# CITY OF PORTLAND, MAINE

## HISTORIC PRESERVATION BOARD

January 14, 2013

Re: Request to install hanging sign - 39 Exchange Street

Front:  
39 Exchange Street

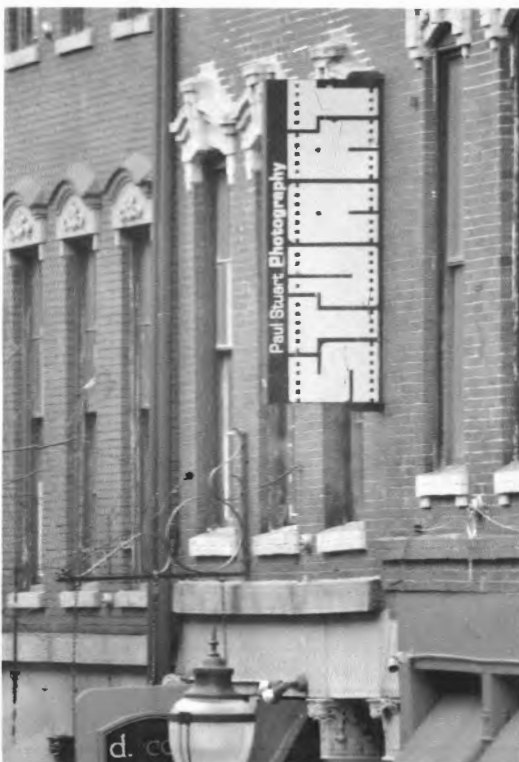
1. Black metal bracket is to be installed in brick masonry joints, in the location discussed with the applicant and illustrated in the marked photo attached to the approval letter – above the left side of the building entrance.
2. The top of the sign board shall be below the bottom of the continuous granite band running across the façade under the window sills.
3. This hanging sign will serve as a building directory sign for all upstairs tenants. Other upper story tenants needing signage will have to be listed in this location, from the same bracket. A directory sign is still allowed on the wall of the entrance alcove.
4. Approval is made with the understanding that no lighting is associated with this installation.
